## Planning Consultation Memo

Date	Planning Officer	Environmental Health Officer
21/01/19	David Elmore	Karl Riahi
Planning Application Number	Worksheet Number	
6/2018/3255/FULL	WK/104622

**Address:** Plot 5610 Hatfield Business Park Gypsy Moth Avenue Hatfield AL10 9BS

**Application Details:** Erection of a pre-delivery inspection facility (Use Class B8), together with car storage area, staff car parking, cycle parking, boundary treatment, landscaping, lighting and access

Proposed Floor Plan

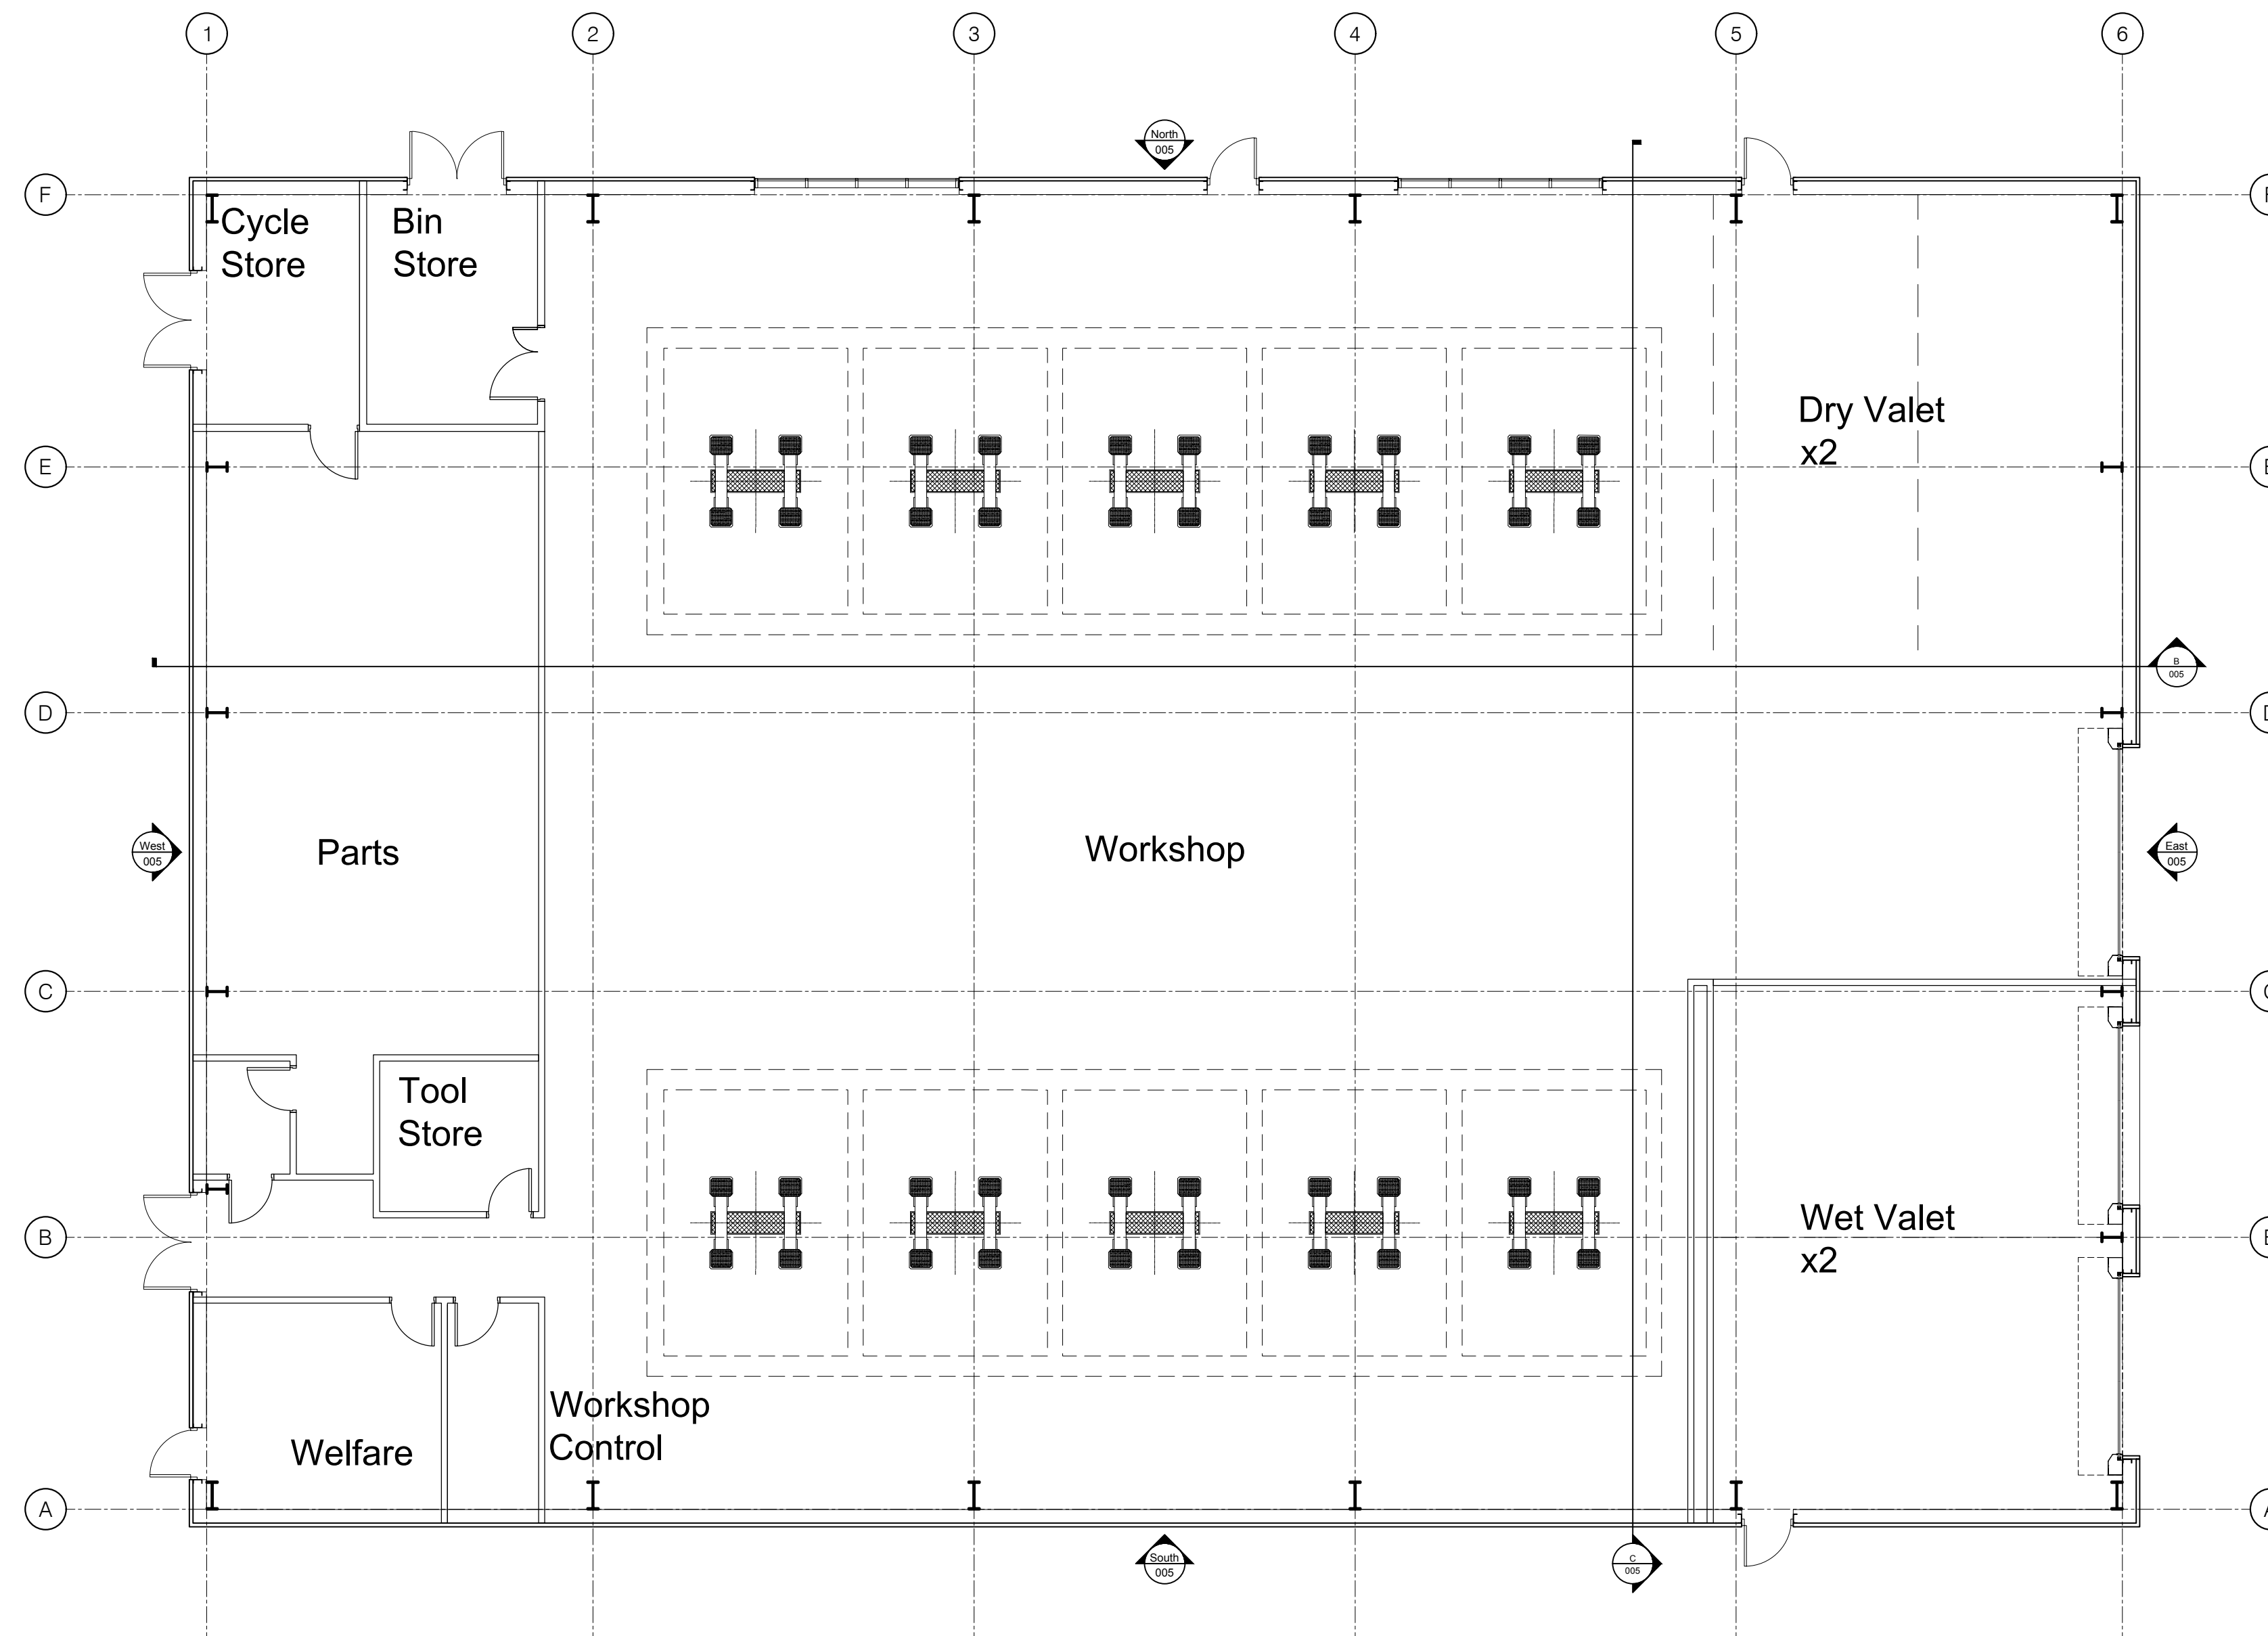
The plans show a workshop area and valet areas, which will have the potential for noise, along with the expected plan associated with ventilation of the unit.

This raises concerns with regards to activities taking place internally within the unit, and some items of equipment can be noisy, especially pneumatic tools. We would expect the doors to remain closed whilst noisy works are taking place, however, viewing the number of servicing bays, this would be difficult to achieve with regular movement of vehicles.

No fabrication, repair work or other such works requiring power tools or hammering shall take place on site external to the proposed building.

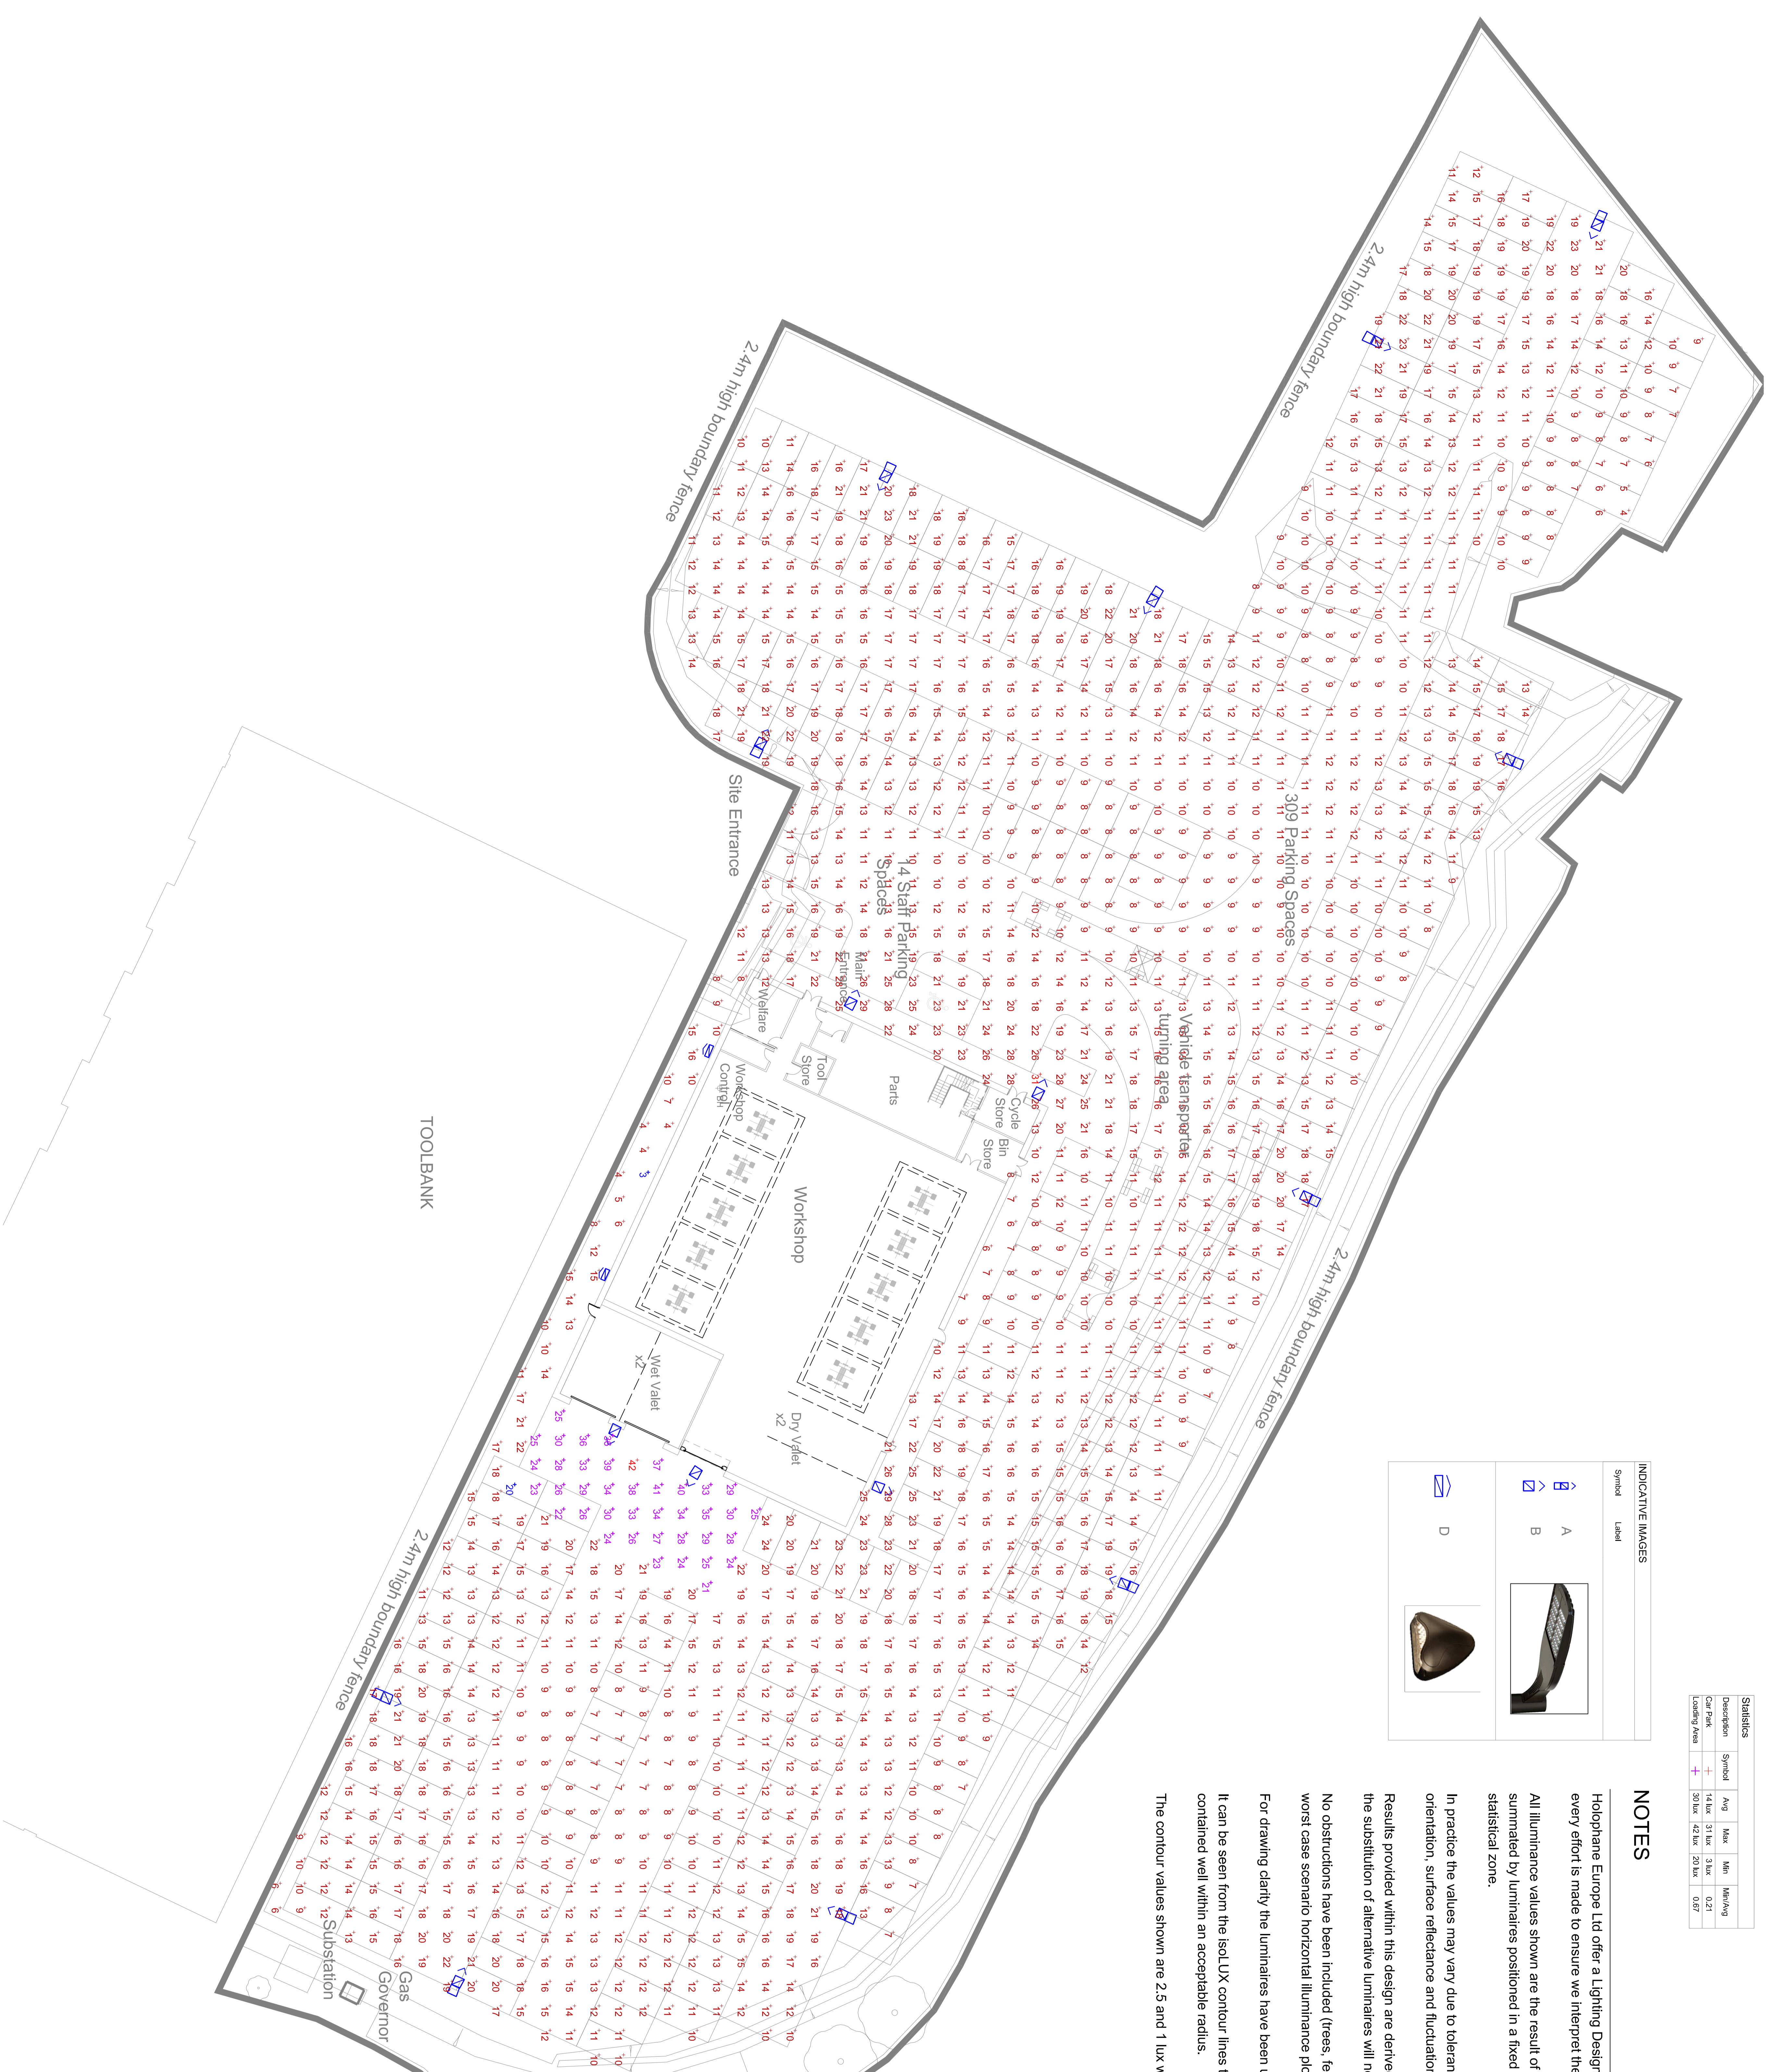
Although a lighting assessment has been provided, it does not show the potential impact on the residential properties along Cornflower Way. Vertical lux diagrams showing the potential trespass into windows of these properties will alleviate some concerns and can be provided through condition.

Prior to installation of external lighting the applicant shall submit to, for approval in writing by the Local Planning Authority, details relating to the external lighting scheme (including vertical lux diagrams which show potential light trespass into windows of nearby residential properties). This scheme must meet the requirements within the Institution of Lighting Professionals guidance notes for the reduction of obtrusive lighting.
